# KITITITAS COUNTY DEPARTMENT OF PUBLIC WORKS

## MEMORANDUM

TO: Kari Braniff, Community Development Services  
FROM: Christina Wollman, Planner II  
DATE: June 5, 2008  
SUBJECT: Additional Information Requested  
DJ Cattle & Land Short Plat SP-08-20

DJ CATTLE & LAND SHORT PLAT

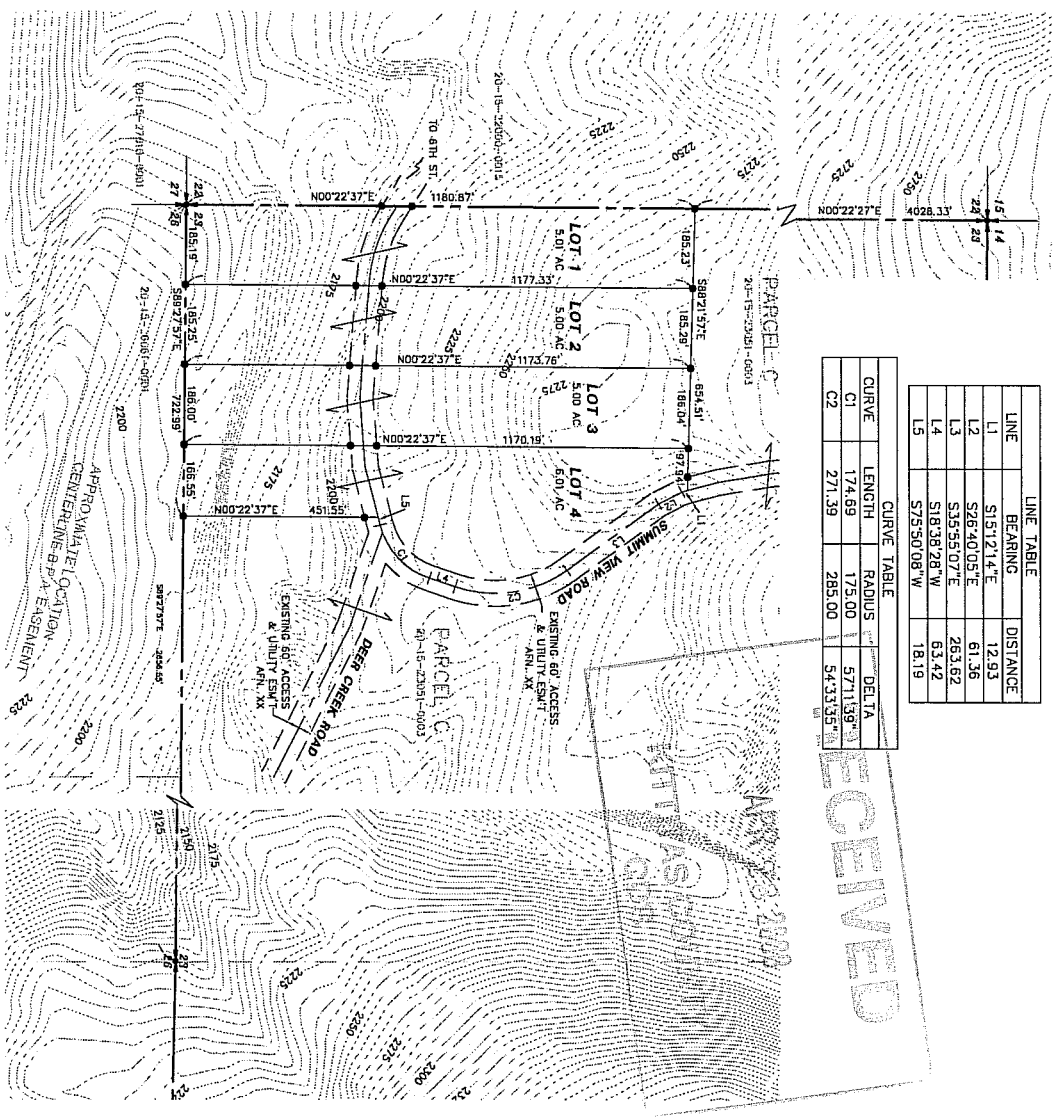
Deer Creek Road currently serves more than 40 lots. Per Kittitas County Road Standards 12.01.095(2), a second access is required. The second access shall be identified prior to preliminary approval.

Additionally, a portion of Deer Creek Road is located within a 30' easement. A 60' easement is required. The applicant will need to apply for and receive a road variance prior to receiving preliminary approval.
